PEZ 2018-011: Building Conversion, 415 Cumberland Avenue

Below are my preliminary comments on the materials submitted to date on the site plan and accompanying materials related to bicycle, pedestrian, streetscape and accessibility topics:

Sheet Title:	<b>SITE PLAN</b>
--------------	------------------

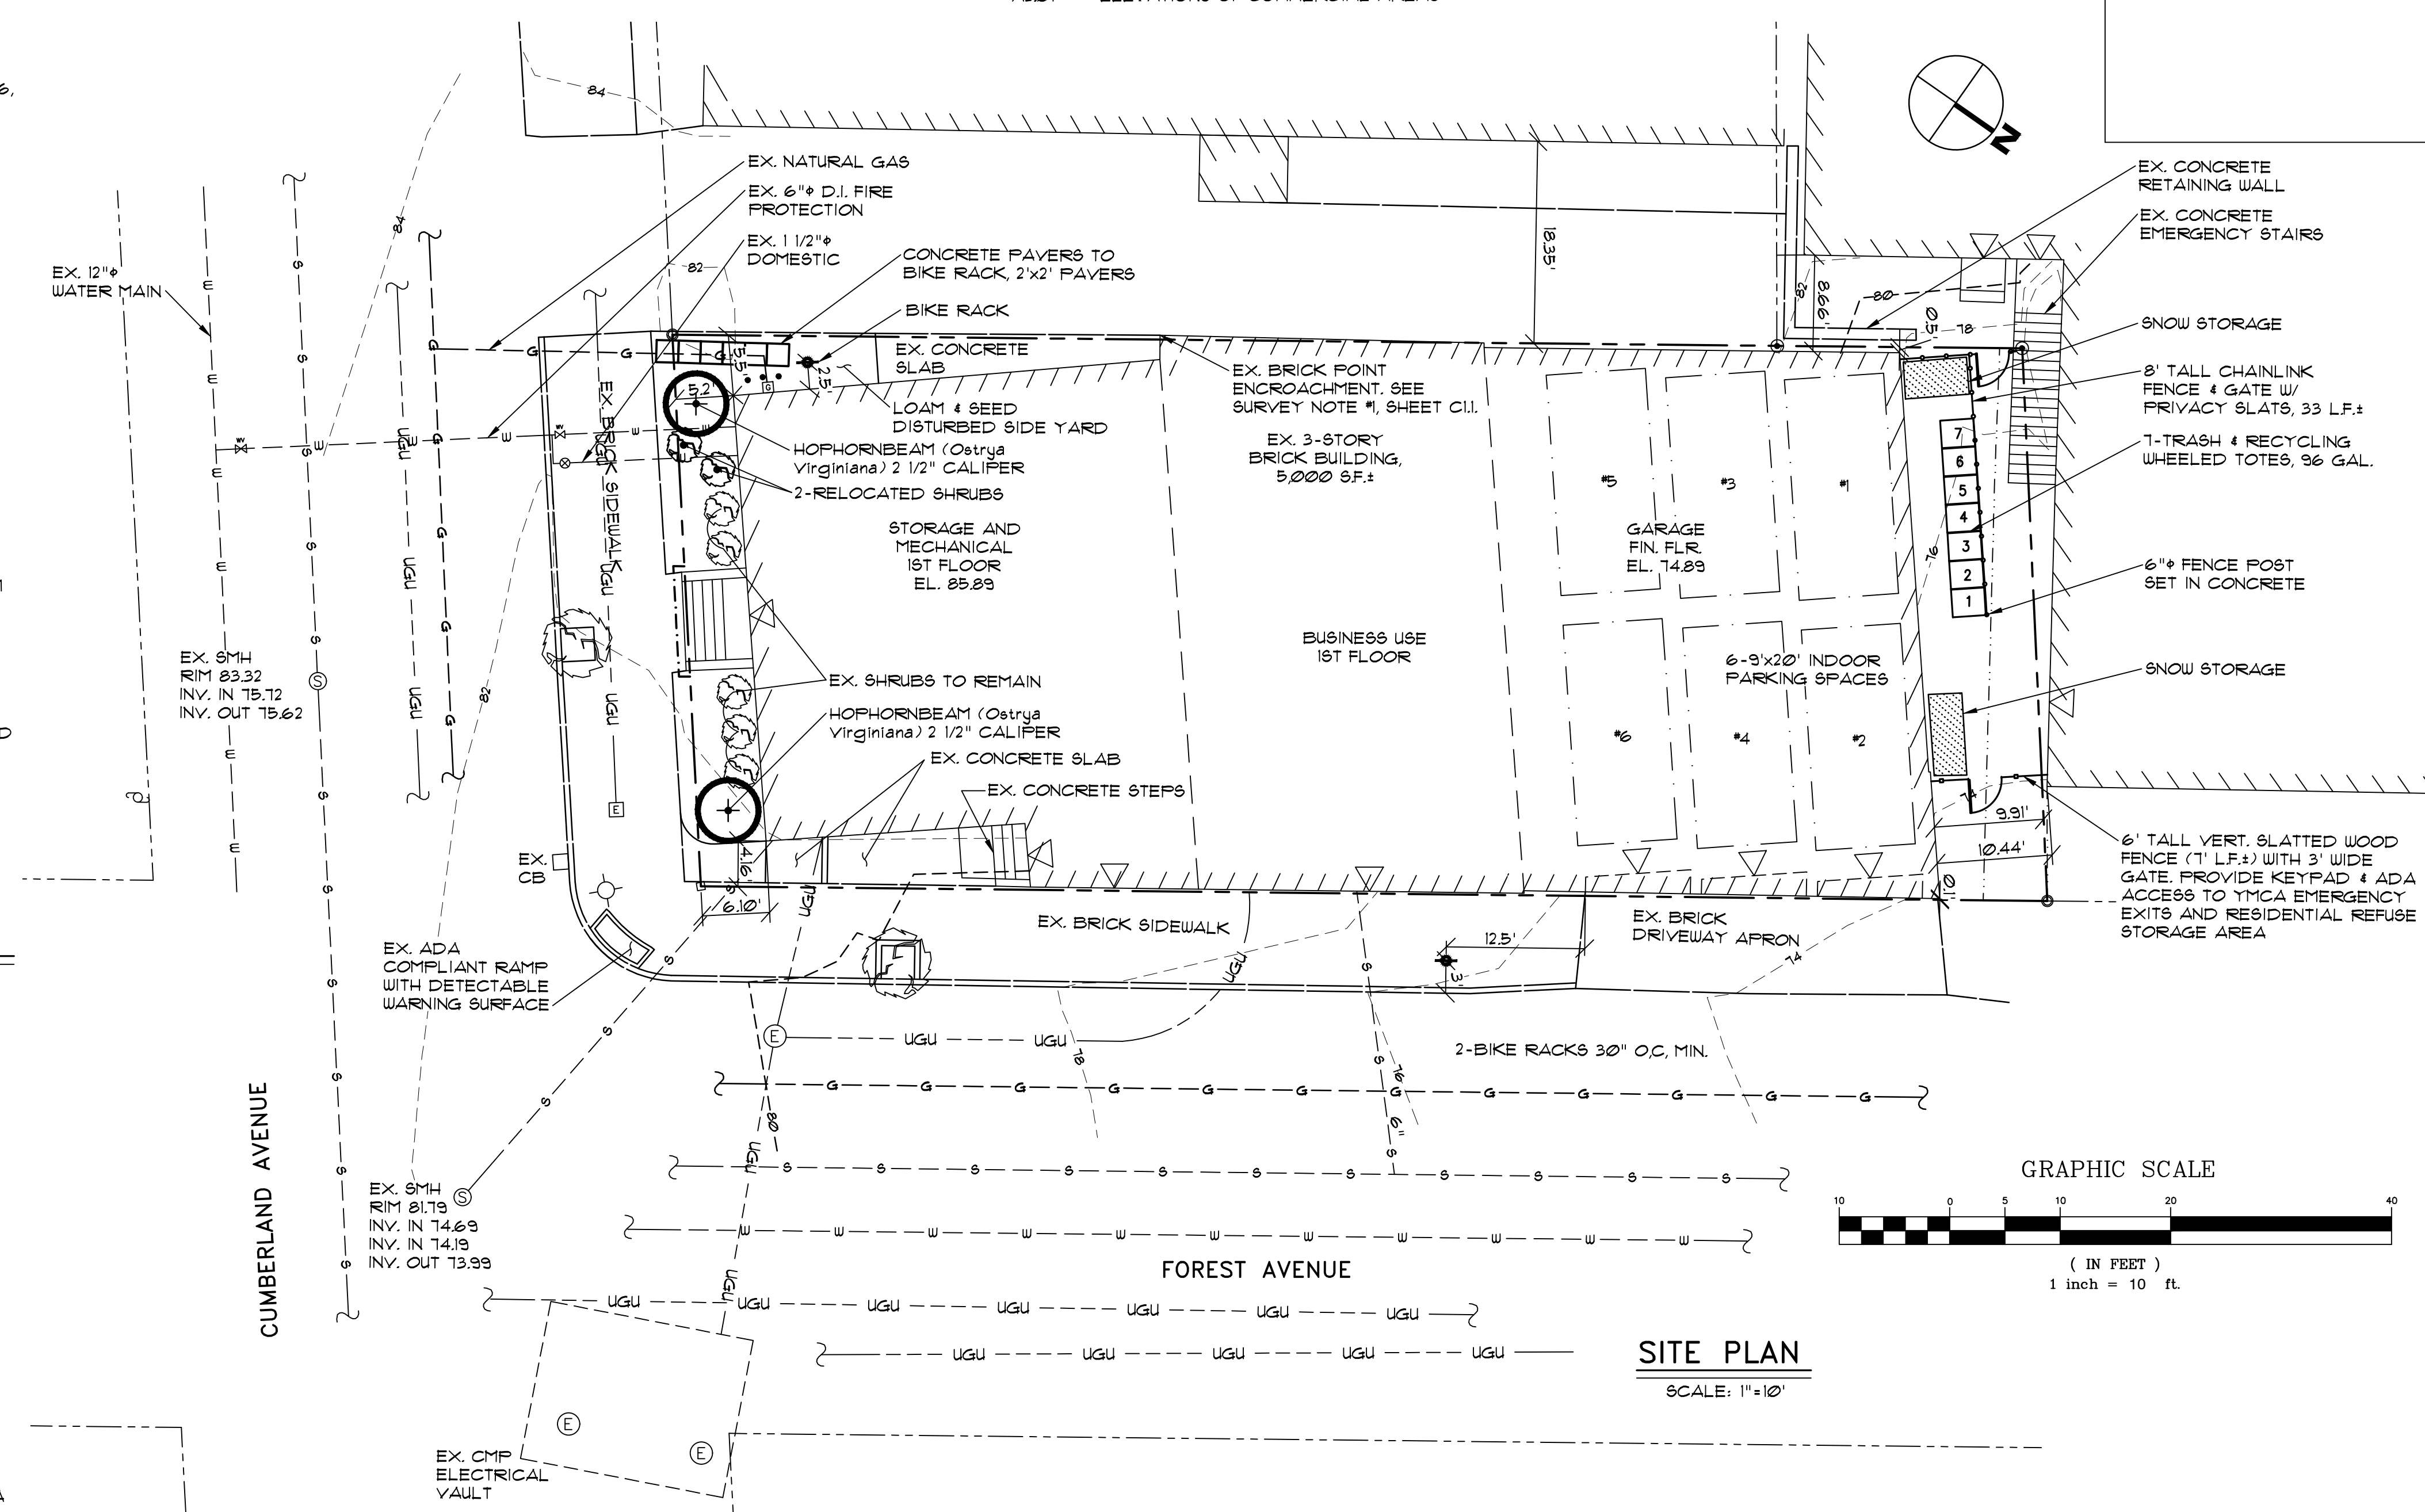
- the city arborist should weigh in the adequacy of the existing tree wells within the sidewalk - they do not meet current dimensional requirements (typically 4'x7') but should be sized appropriately, if adjusted, to maintain the width for pedestrian accessibility along the sidewalk (5' ideal minimum)

- the curb ramp is to be updated to achieve full ADA-compliance and meet existing Technical Standards - I've attached the curb ramp configuration provided to the previous applicant's project team for this location - the current standard for the detectable warning panel within the curb ramp is cast iron with a 4" concrete border and is available from DPW if needed

- the layout and dimensions for the 2 bicycle racks need to be checked for adequacy - the minimum clearance (O.C) are: from the building, 30"; between racks is 36" and from the edge of the driveway is 24". Sufficient clearance from the exterior gas service and bollards also need to be considered. It appears the bike racks would also block access to the external stairway from the 2nd floor without going onto the adjacent property. Other locations on-site or within the sidewalk on either Forest and/or Cumberland Avenue can also be considered to make them more functional and not block this access.

- the ADA-compliance of the sidewalk and driveway along the project's frontage on Forest Avenue should be confirmed for cross-slope (maximum 2% cross-slope for a minimum of 5' of width) and condition.
